HARNETT COUNTY

DEPARTMENT OF PUBLIC HEALTH

DATE: October 15, 1997

Re: Sarah Clark Property

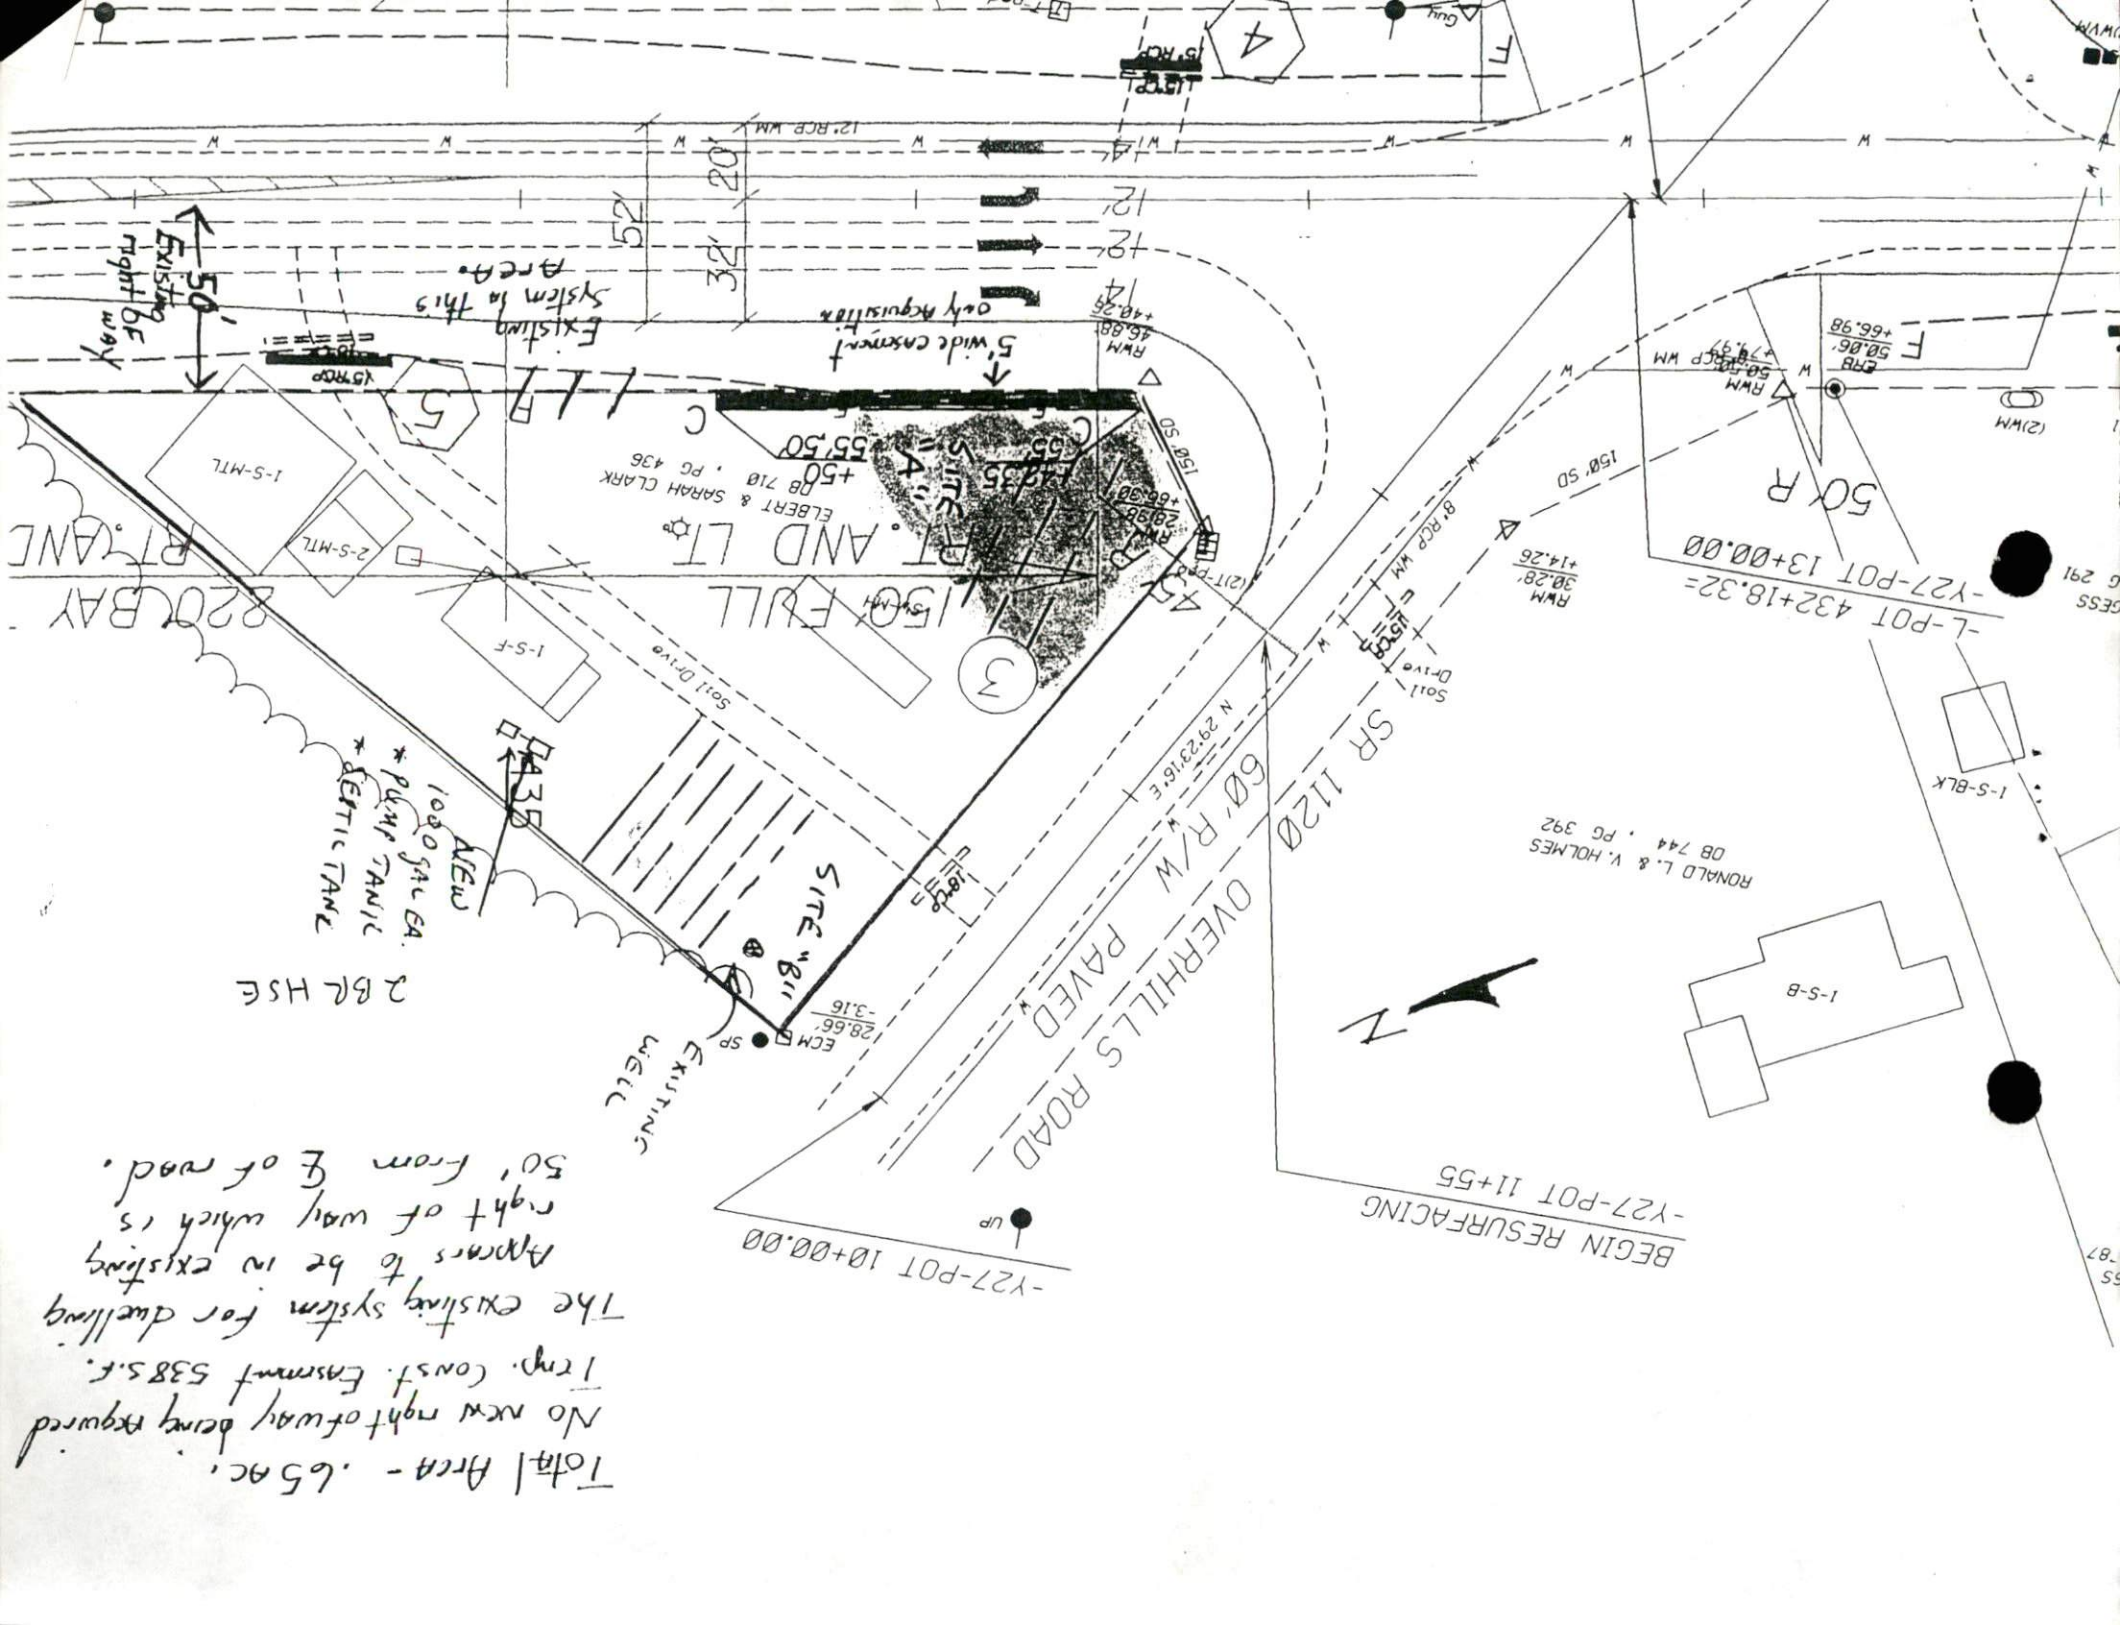
Based on a site evaluation conducted on October 14, 1997, Ms. Clark's septic system can be relocated to the front yard adjacent to SR 1120. The system would comprise of a 1000 gallon septic tank and a 1000 gallon pump and 270 total linear feet of drainline. The well next to the right of way would have to be properly abandoned and the new system would require at least six inches of cover.
